Date: April 29, 2024

Re: Framing Item
Lot 104 Atherstone - 208 Ivy Bank Drive (Angier, NC)

The client referenced above requests **Queen City Consulting and Design, PLLC** to evaluate framing items at the address referenced above. The structural plans were provided by Queen City Consulting and Design, and sealed by Christopher T. Blackwell on January 22, 2024. All orientations in the report reference directions as if the reader is viewing the front of the house from the street.

SHEET NAME:  
**FIRST FLOOR FRAMING PLAN**

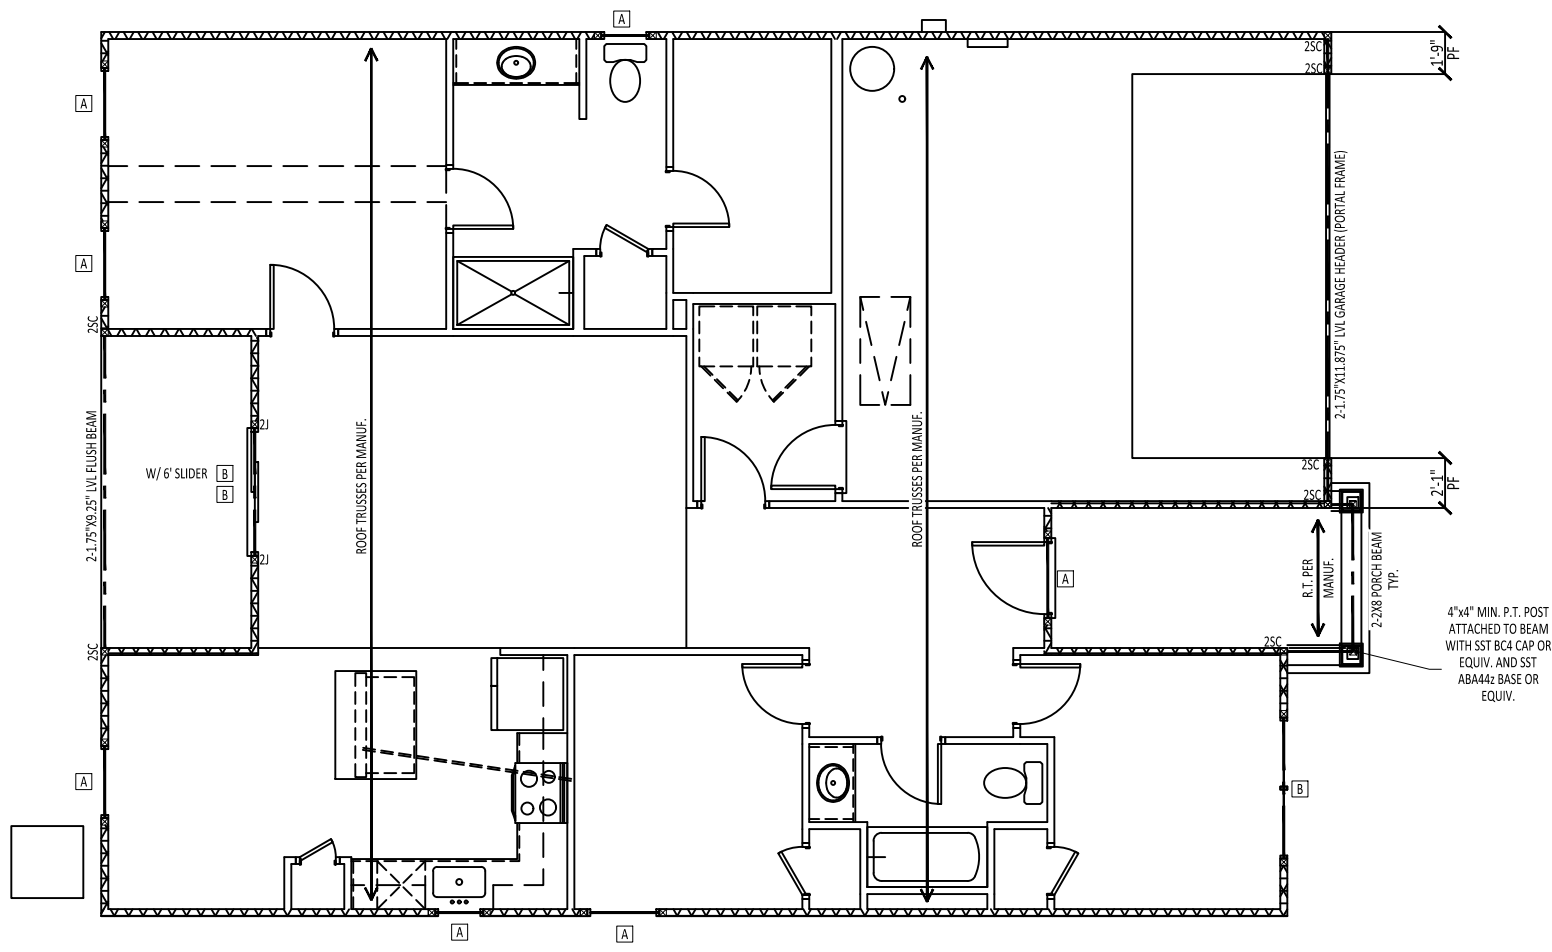
Contractor has requested the evaluation of the existing 2-2x10 header that has been installed over the rear porch in lieu of the 2-1.75"x9.25" LVL as shown on the plans.

Based on our review, the contractor shall sister the existing 2-2x10 with a full length 2x10 ply. Attach the additional ply to the existing 2-2x10 with (3) 1/4"x4" SDS screws spaced at 16" o.c. The 2x10 ply will overhang the existing load bearing wall on the interior side of the house, however, the now 3-2x10 will have adequate bearing.
